Applicant's Response to CCS Local Impact Report

PINS Reference Number: EN010069

Deadline 2 – 30 November 2018

- 1.1.1 The Applicant, Abergelli Power Limited, is applying to the Secretary of State (SoS) under the Planning Act 2008 (PA 2008) for development consent to construct, operate and maintain an Open Cycle Gas Turbine (OCGT) gas fired peaking power generating station, fuelled by natural gas with a rated electrical output of up to 299 Megawatts (MW) (the Abergelli Power Project).
- 1.1.2 The Development Consent Order (DCO) Application for the Abergelli Power Project (the Project) was submitted by the Applicant to the SoS in May 2018. It was formally accepted to progress to examination in June 2018.
- 1.1.3 This document contains the Applicant's comments in response to the Local Impact Report submitted to the ExA by City and County of Swansea Council (CCS) at Deadline 1.

Noise Sensitive Receptor	Address
NSR1	Cefn-betingau
NSR2	Feline Wen Farm
NSR3	Llwynhelig
NSR4	Maes-eglwys
NSR5	Lletty Morfil Farm
NSR6	Abergelli Farm

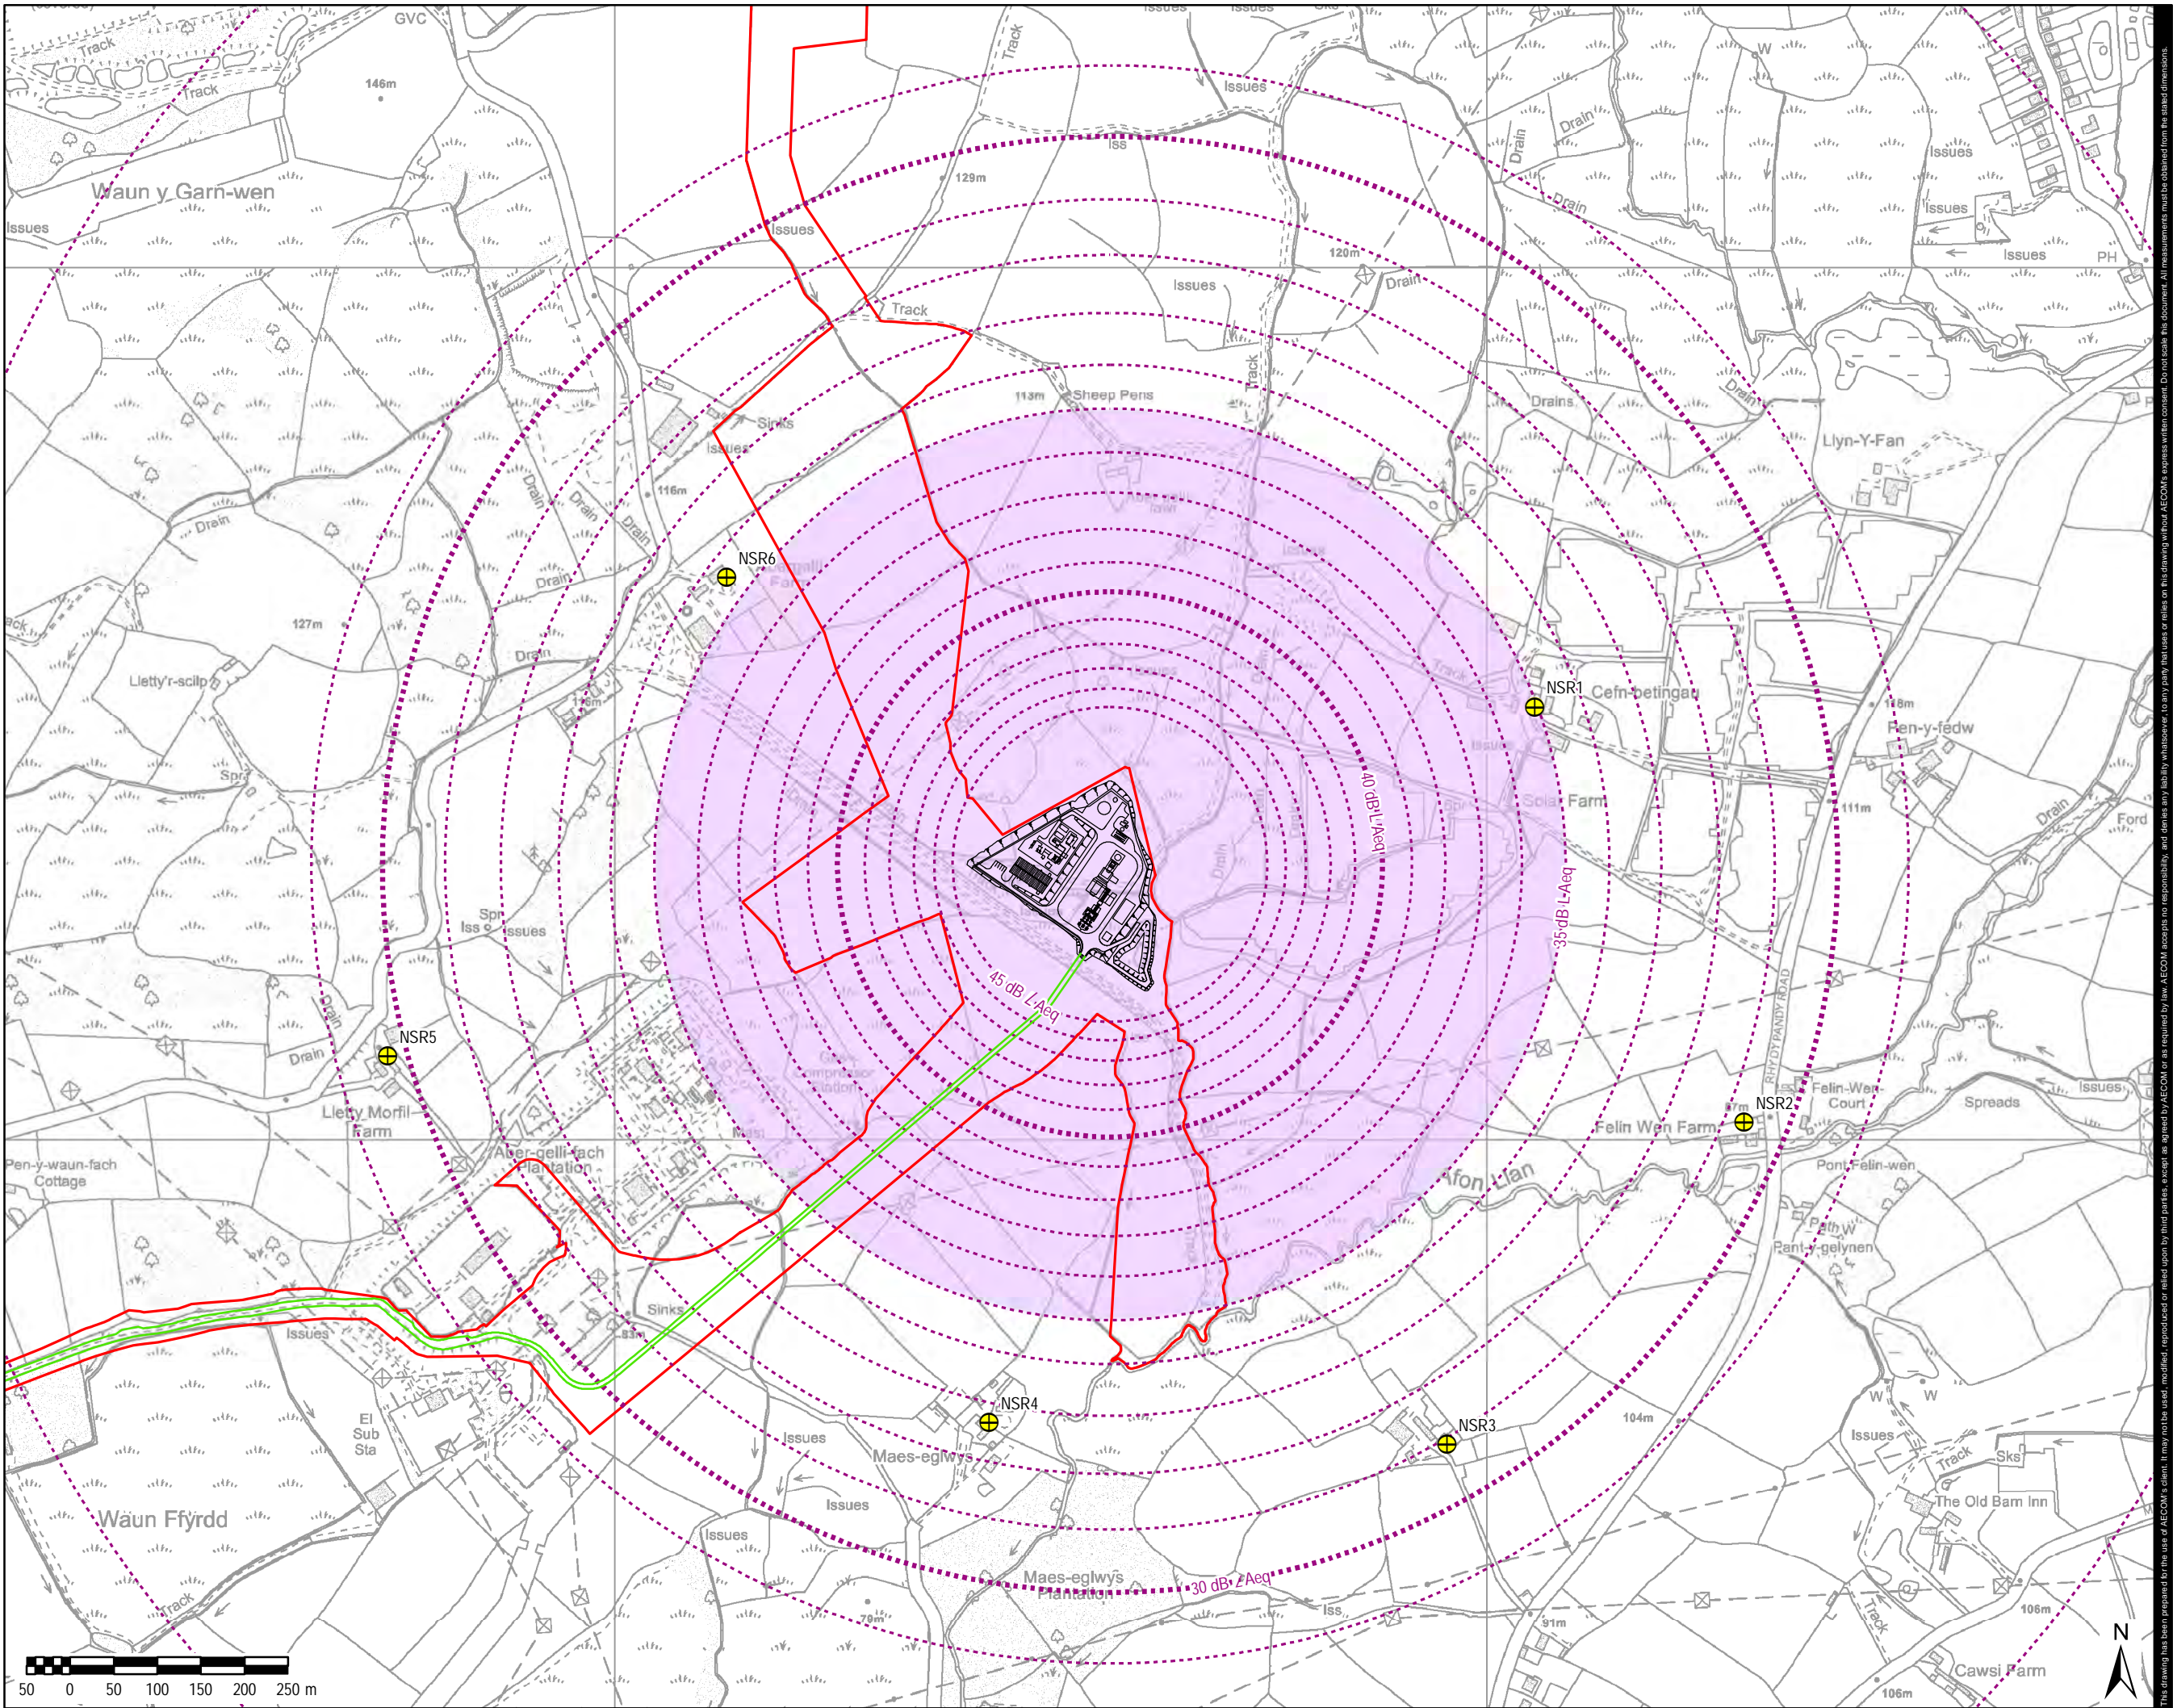
10.14	CCS does not agree with rating levels set out in column A of Table 3 of Requirement 25. The dBL _{ARs} stated are higher than those set out in table 7-21 of the ES which had already included a +3dB correction; the dBL _{ARs} put forward would place the NSR's in a Classification of effects 'minor' (Table 7-14) The increase in difference stated could allow for an increase in noise to be permitted and given the context of the area lead to the creation of significant disturbance to the neighbouring land uses. Requirement 25 should therefore be amended to reflect this.	<p>Table 3 of Requirement 25 of the draft DCO [APP-014] gives operational noise limits for the Project. These were set at the lowest level at each receptor which would result in a minor effect. In other words noise levels which meet the operational noise limits listed in the DCO will result in negligible effects. ES [APP-042] Chapter 7: Noise and Vibration uses the same principles to assess the expected effects of the predicted sound emissions from the Project but does not list the operational noise limits themselves.</p> <p>Tables 7-12 and 7-14 in the ES [APP-042] identify that the onset of minor effects for residential properties would be expected to occur with rating levels more than 5 dB above the representative background sound level. This is the basis for the operational noise limits included in Table 3 of Requirement 25 of the draft DCO [APP-014].</p> <p>The difference can be summarised as follows for the night time scenario.</p>

Noise Sensitive Receptor (NSR) Column	Measured representative night time background sound level as shown in ES Tables 7-15 and 7-21	Operational noise limit (background sound level plus 5 dB) as shown in DCO Table 3	Predicted specific sound level (L_{Aeq}) as shown in ES Tables 7-20 and 7-21	Predicted rating level (L_{Ar}) - specific sound level plus 3 dB character correction for intermittent operation as shown in ES Table 7-21	Difference between rating level and background sound level as shown in ES Table 7-21	Difference between rating level and operational noise limit showing all rating levels below the operational noise limit for relevant receptor
Calculation		A + 5		C + 3	D - A	D - B
Cefn Betingau	34	39	35	38	+4	-1
Maes-eglwys	35	40	32	35	0	-5
Lletty Morfil Farm	38	43	29	32	-6	-11
Abergelli Farm	36	41	34	37	1	-4

The differences between the operational noise limits and the predicted rating levels shown above are a function of the conditions of the Project Site. The rating levels are based on the predicted specific plant sound level at each receptor. The predicted levels are highest at those receptors closest to the Project Site. But the background sound

<p>levels are unrelated to the distance from the Project Site as the sound sources contributing to the background sound level are located at various points none of which are on the Project. As the operational noise limits are based upon the background sound levels they too are independent of distance from the Project Site. As a result, there is essentially only one crucial location, Cefn Betingau ((Noise Sensitive Receptor (NSR) 1), which is closest to the Project Site and has the lowest background sound level of 34 dB. Lletty Morfil (NSR5), on the other hand is furthest from the Project Site and has the highest background sound level of 38 dB. As a result the same plant sound output produces very different BS 4142 assessments for the two NSRs.</p> <p>A plant designed to meet the operational noise limit at Cefn Betingau (NSR1) will result in rating levels considerably below the operational noise limits at the other receptors. The predictions in Table 7-21 show night time rating levels 1 dB below the operational noise limit at Cefn Betingau and 11 dB below the operational noise limit at Lletty Morfil (NSR5).</p> <p>The operational noise limits are rating levels, so include penalties for the character of the sound. ES [APP-042] Chapter 7: Noise and Vibration includes a 3 dB penalty in the predictions to reflect the intermittent nature of the source (it is a peaking plant), therefore the specific sound level (before character penalties added) at Cefn Betingau (NSR1) was 4 dB below the operational noise limit. If the sound produced by the plant includes other characteristics that would attract character penalties (tonality, impulsiveness) then these additional penalties would have to be added as well to allow comparison with the operational noise limits. It is the intention of the detailed design to avoid this but if such characteristics cannot be avoided then the specific sound level of the plant will be lower to allow for the addition of the penalties in the rating level for comparison with the operational noise limit.</p>
